Consultation Response from KC, Conservation & Design
2022/92314 100, St John's Road, Birkby, Huddersfield, HD1 5EY
Erection of single and two storey side and single storey rear extensions to increase ground floor retail unit and HMO above (within a Conservation Area) (modified proposal)
Date Responded: 7.9.22
Responding Officer: Sue Brooks
Responding Ref:

client	MR CHAHAL		
project	100 ST JOHN'S ROAD BIRKBY HUDDERSFIELD HD1 5EY		
drawing	PROPOSED ROOF AND BLOCK PLAN		
revision	notes	date	drawn
*	*	*	*
scale :	1:50 & 1:200 AT A1	07.22	PB
project no.		drawing no.	revision
2210		04

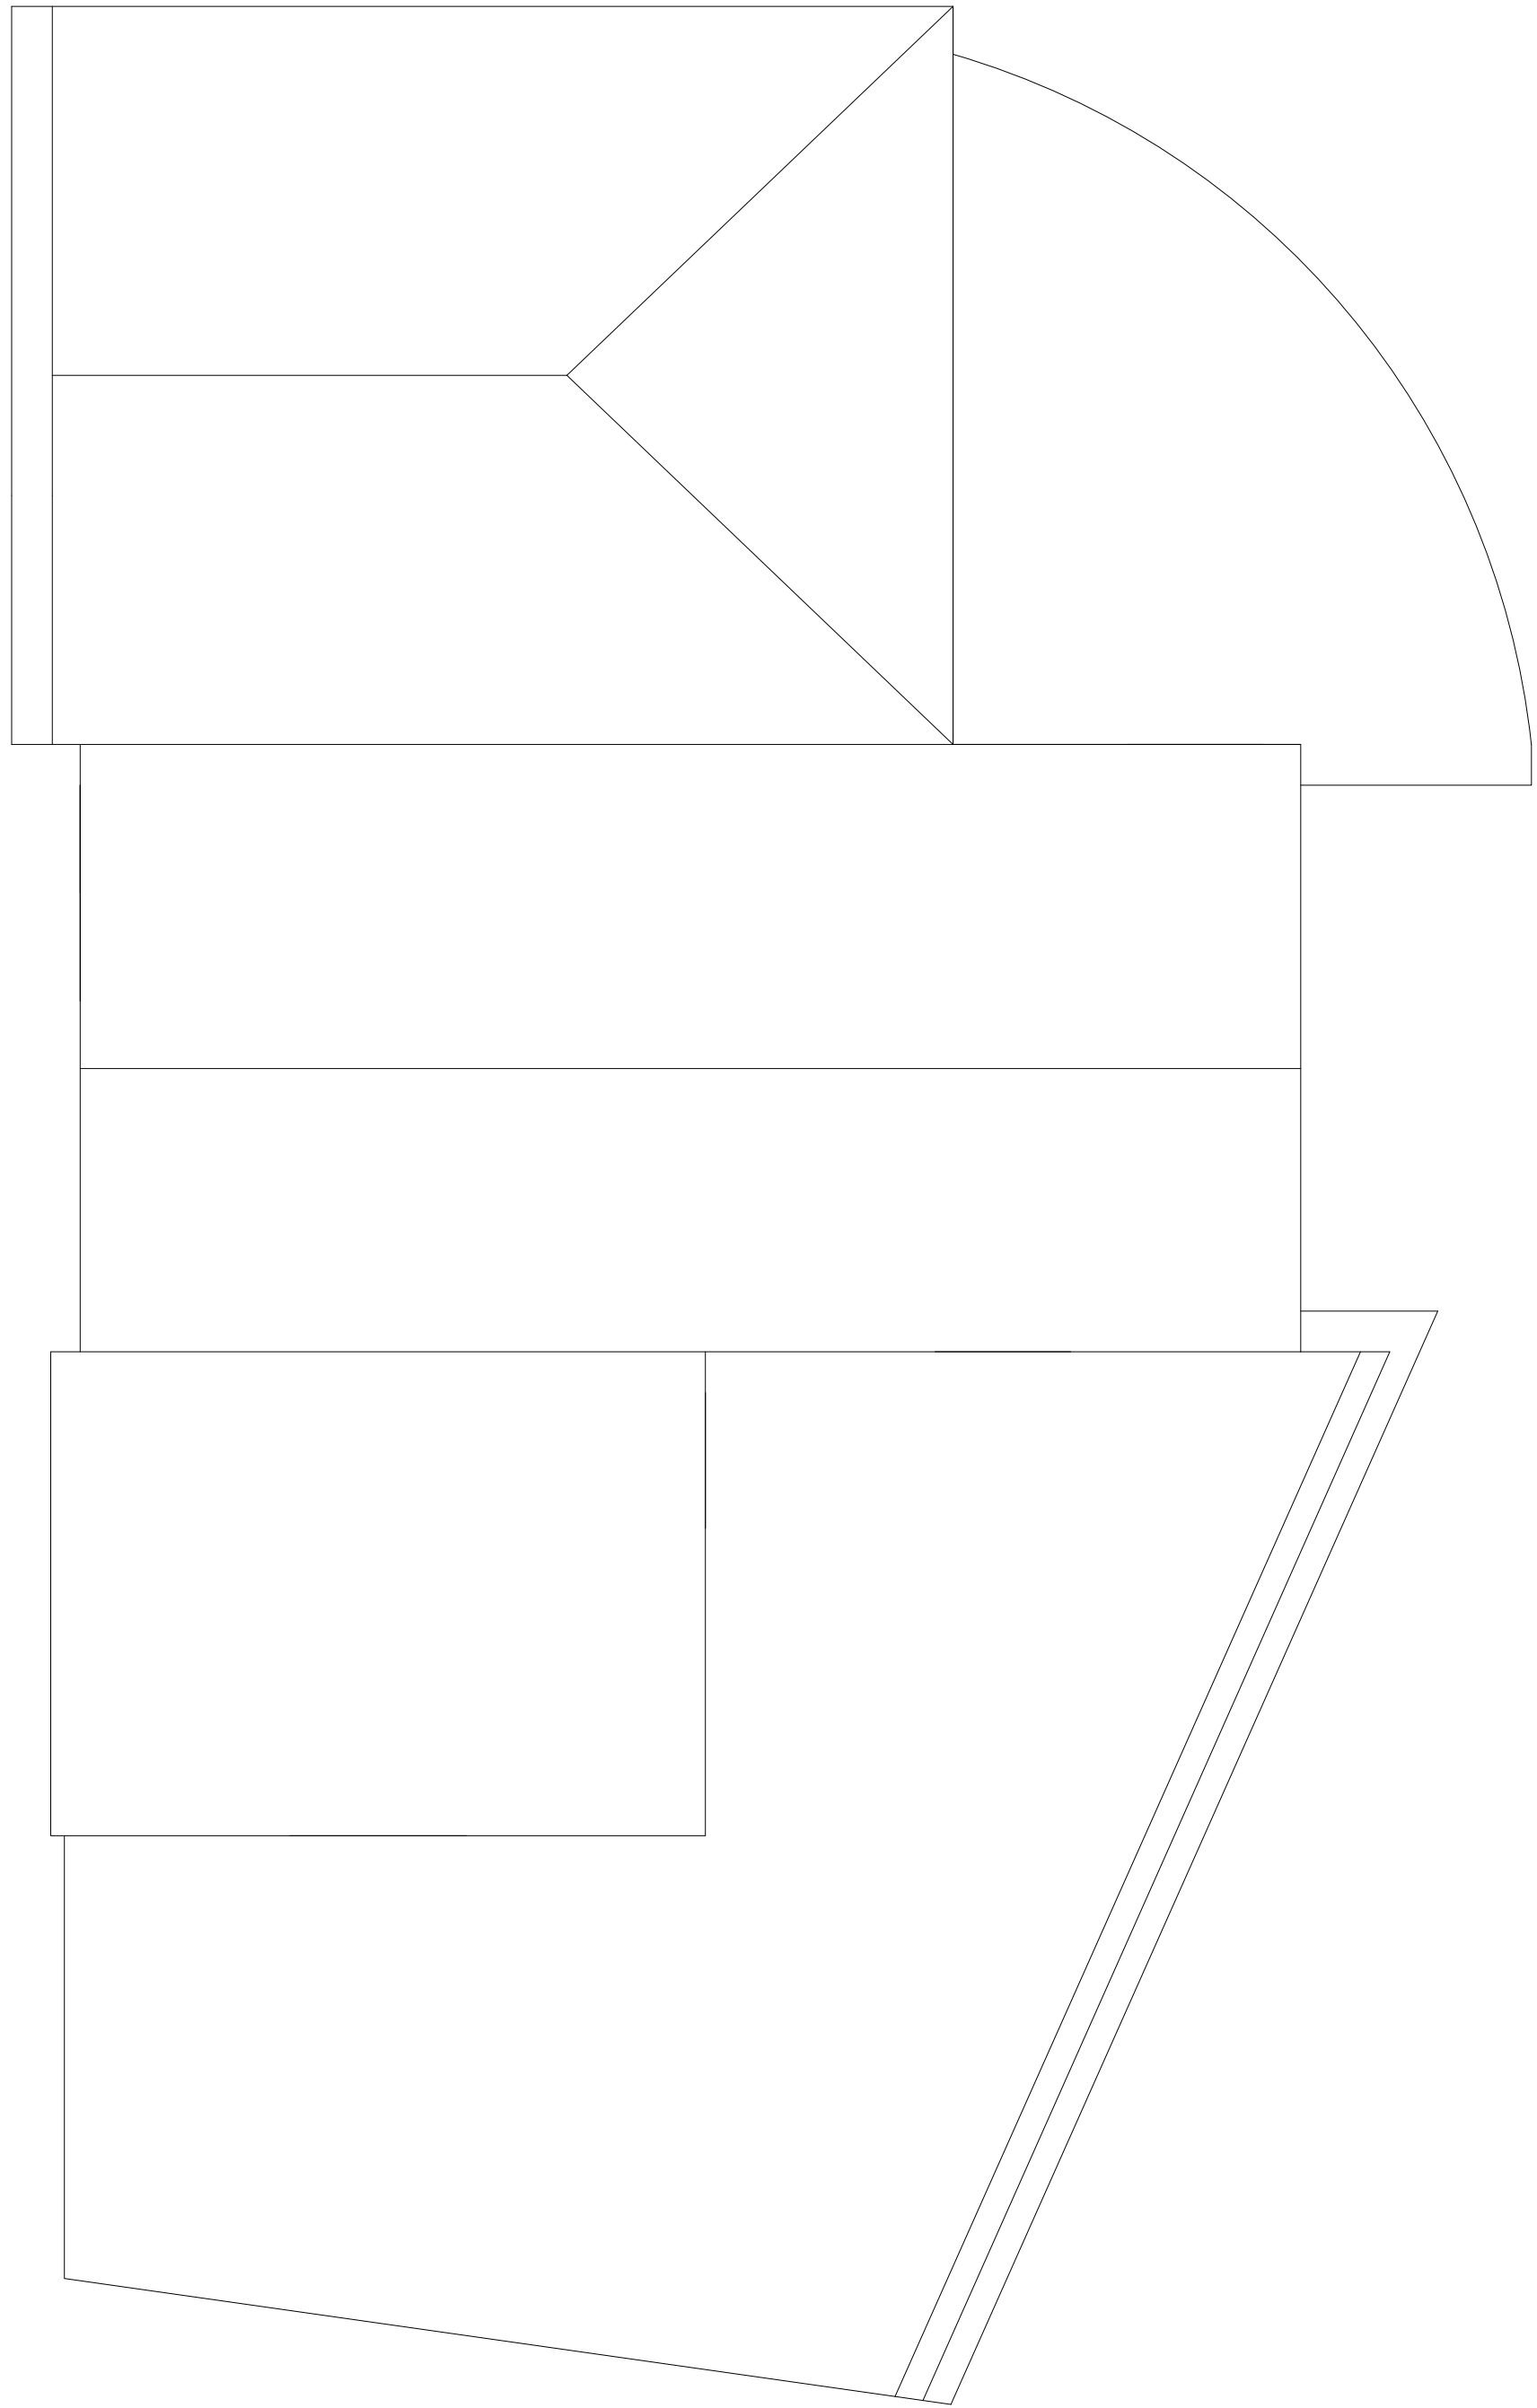
As before, the amount of development on this site is substantial, with the proposed single storey flat-roofed side extension extending as far as the curved boundary of the site and beyond the historic building line of the terraced properties on Blacker Road to the rear. We would still consider this to be overdevelopment of the site in this key corner location and therefore we do not consider that the proposed development preserves and enhances the character of the conservation area. It does not meet the requirements of Policy LP35 of the Local Plan and is contrary to Policy 72 of the Planning (Listed Building and Conservation Areas) Act.
